PORTLAND MAINE

31 December 2012

**RE: The Capacity to Handle Wastewater Flows, from the Proposed Conversion, of
the Former Gannett Building, at 119 Exchange Street, into a Hotel and Restaurant.**

GREASE TRAP DETAIL
N.T.S.

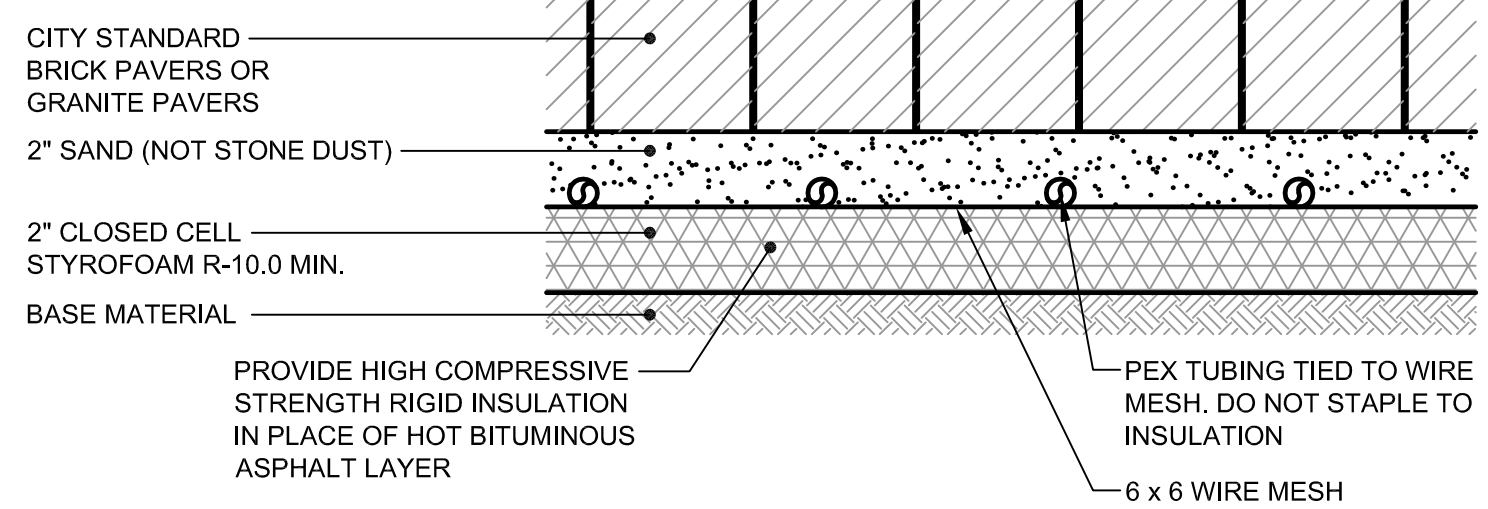
Please address the following. 1. Show the location of the external grease trap, on your utility plan. 2. Show the location of the control manhole associated with the external grease trap, on your utility plan. 3. Show the sizing calculations, for your external grease trap, in terms of the restaurant process flows.
